**Our Case Number:** ABP-317809-23

**Re:** Proposed Coolglass windfarm and related works  
In the townlands of Fossy Upper, Aghoney, Gorreelagh, Knocklead, Scotland, Brennanshill,  
Monamantry, Coolglass, Crissard and Kylenebehy, Co. Laois.

**Our Ref:** ABPE-ABPE-A230810-0040

<b>Proposed Strategic Infrastructure Development (SID): Coolglass Wind Farm SID Application</b>
---

Figure 7-3 Laois CDP Map 3.2 – Wind Energy (Site superimposed)

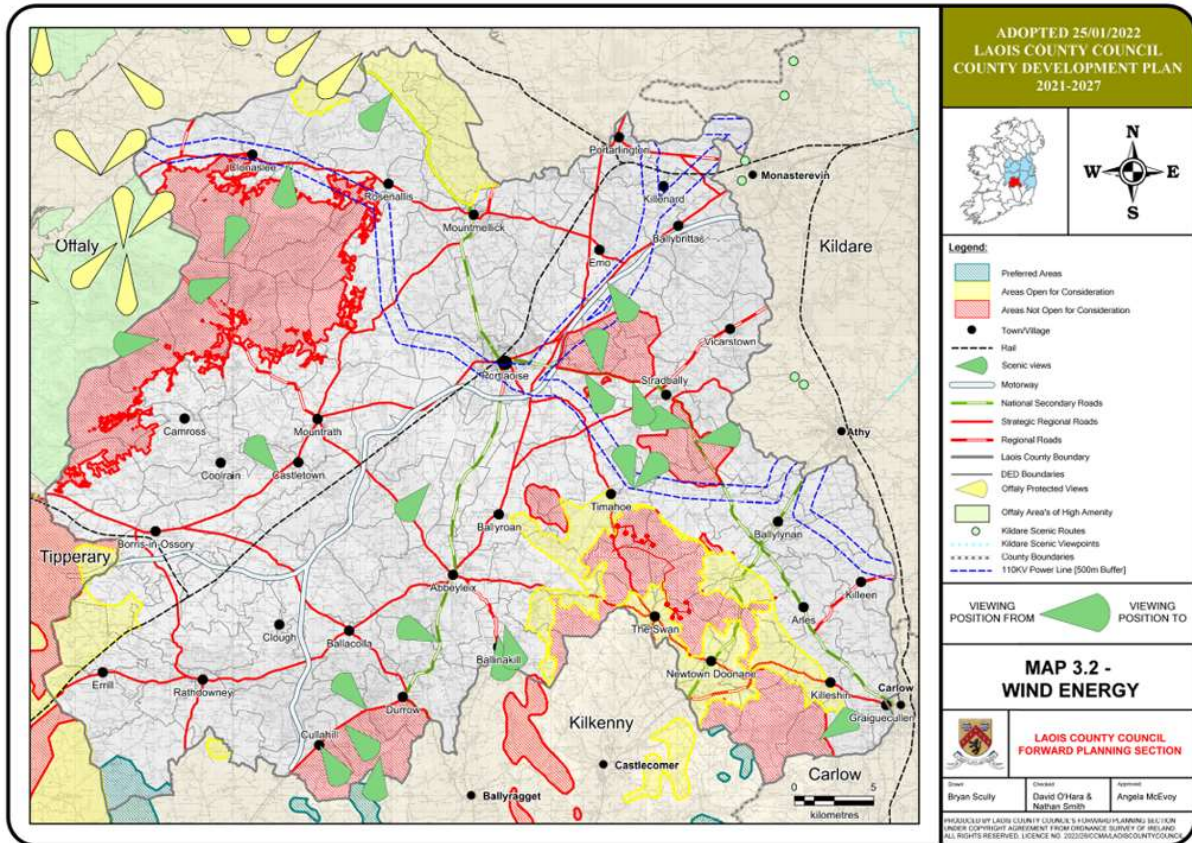
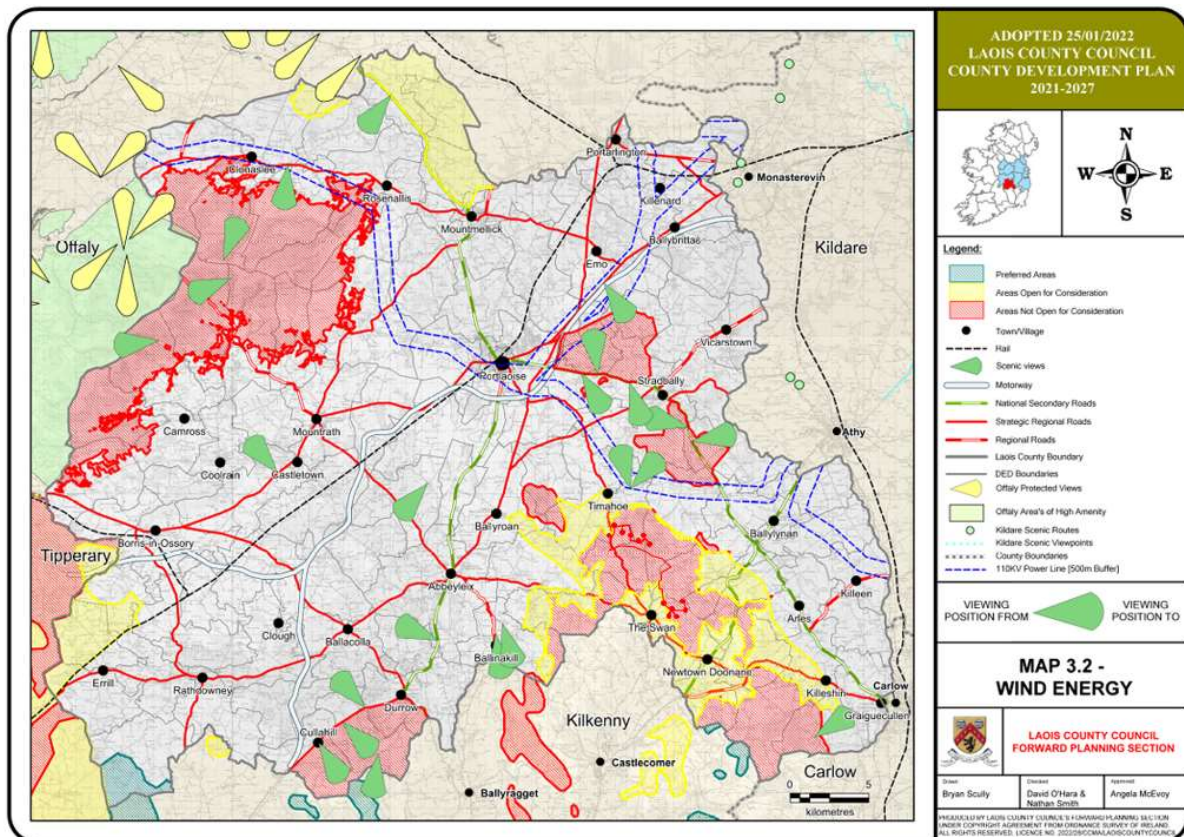
- The development, if permitted, would be in conflict with stated objectives for the protection of archaeological and cultural heritage and the proposed development is located in an area deemed 'Not Open for Consideration' for Wind Energy in the Development Plan.

In addition the PDS is located within an area that has been zoned as 'Not Open for Consideration' for Wind Energy in the *Laois County Development Plan 2021–2027*:

- **WES 7:** Areas Not Open for Consideration. These areas are not considered suitable for wind farm development due to their overall sensitivity arising from landscape, ecological, recreational and/or cultural and built heritage resources as well as their limited wind regime.

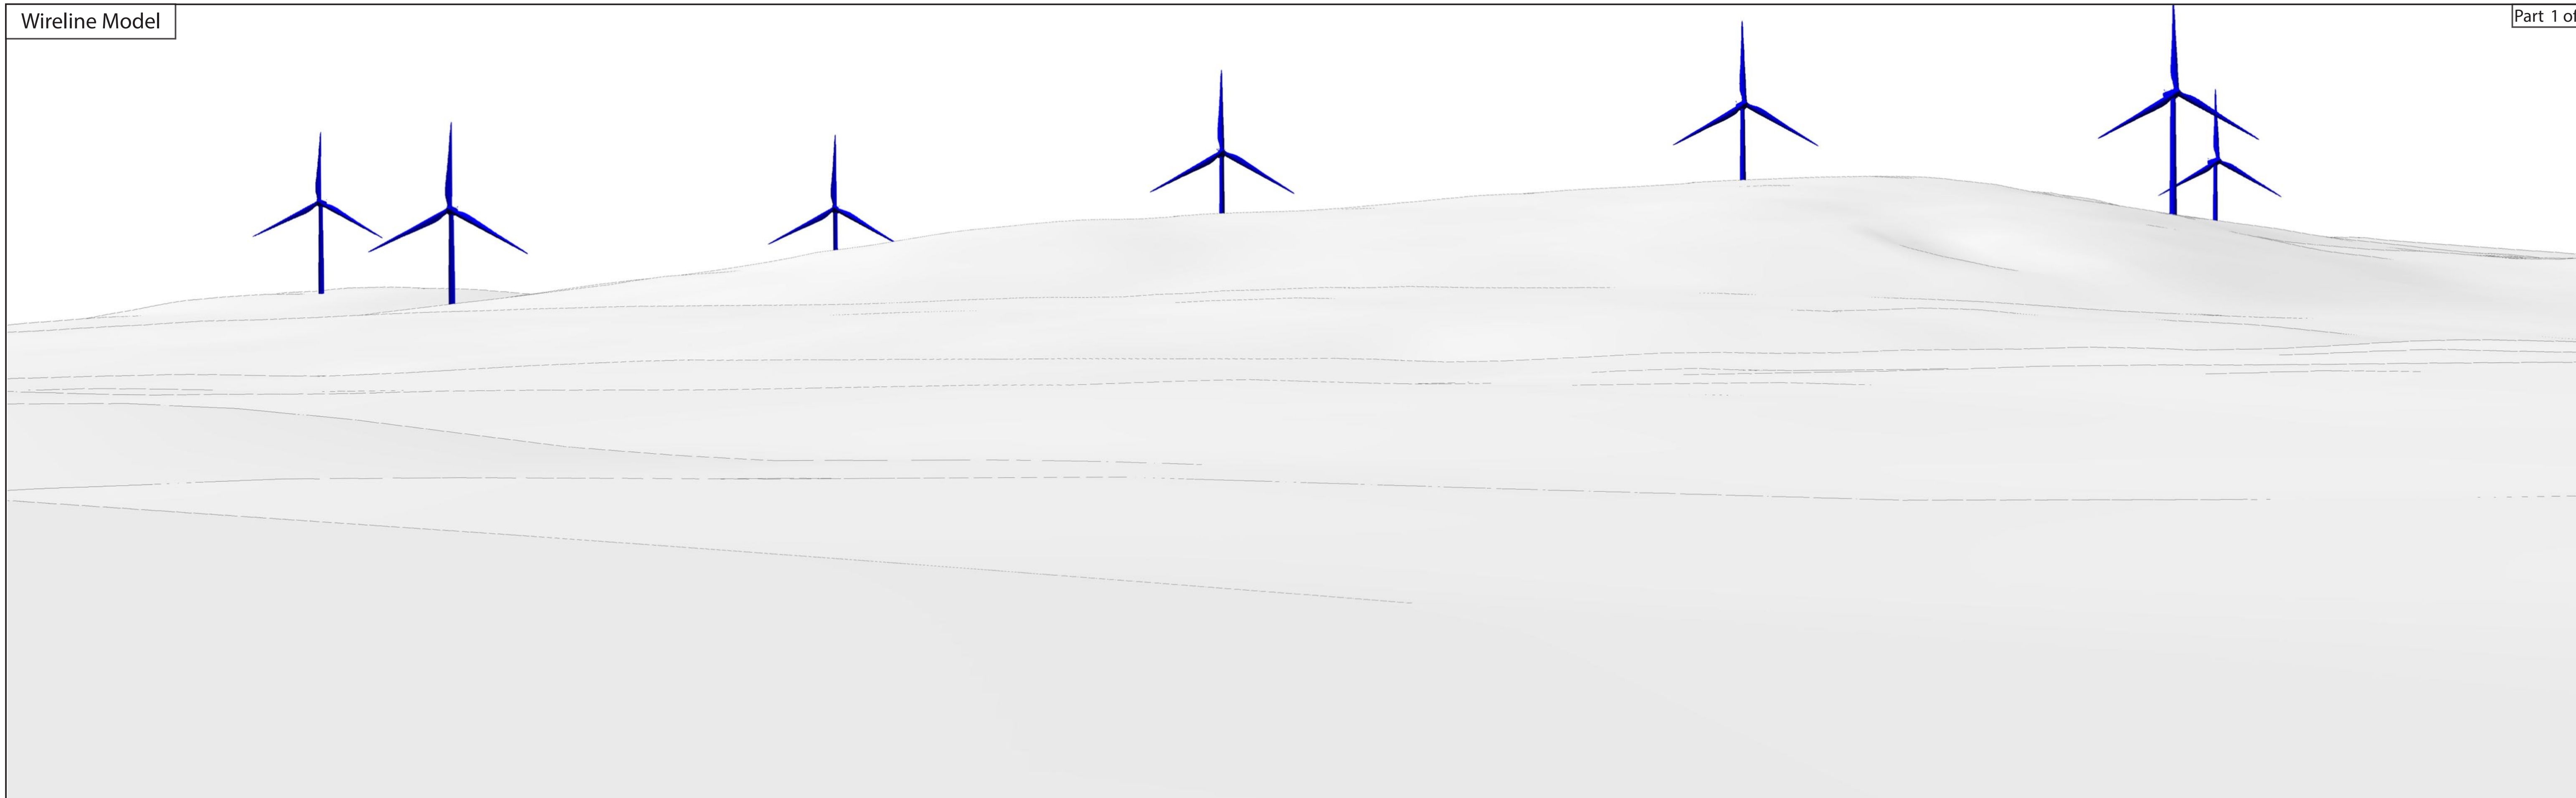
- The Landscape and Visual Impact Assessment chapter of the EIAR presents only a single viewpoint and photomontage as a basis from which to assess of the visual impact of the proposed development to the National Monuments at Timahoe and Fossy.

- The Cultural Heritage chapter of the EIAR presents a narrative discussion of the potential impact on the setting of certain vulnerable monuments (including the church and round tower at Timahoe and the church at Fossy). However, this is not supported by any photographs or photomontages other than the single viewpoint (VP9 at Timahoe) prepared as part of the general Landscape and Visual Impact Assessment.

The Landscape and Visual Impact Assessment chapter of the EIAR presents only a single viewpoint (VP9) and photomontage as a basis from which to assess the visual impact of the proposed development to the National Monuments at Timahoe—Church and Round Tower (NM No 114; RMP LA018-031002-; LA018-031005-). None at all that are relevant for Fossy Church (NM No 114; RMP LA019-016----) or the motte and castle site at Ballinaclogh Lower (RMP LA024-015001-; LA024-015002-) that is subject to a Preservation Order (PO 4/1981) are included.

VP9 is located at the northeast side of the central green in the village of Timahoe, looking across that green towards the PDS. While the current 19<sup>th</sup>-century Catholic parish church in the village is within the viewshed for the photomontage, the site of the early medieval church and round tower is located further to the west, out of shot. No element of the National Monument appears in frame, however, the montage and supporting wireframe does indicate that at least four of the turbines will be prominent along the ridgeline of Fossy Mountain as viewed from the north and northwest.

The EIAR, as submitted, is potentially deficient as the baseline archaeological and cultural heritage environment has not been adequately characterised. The potential impact to the setting and amenity of the National Monuments at Timahoe and Fossy must also be more fully addressed. Therefore, the assessment of the likely impacts and effects of this development to the archaeological resource cannot be evaluated reliably. The Department recommends that permission should not be granted in this case before the inadequacies

identified in the EIAR have been addressed and a revised EIAR document made available as further information.
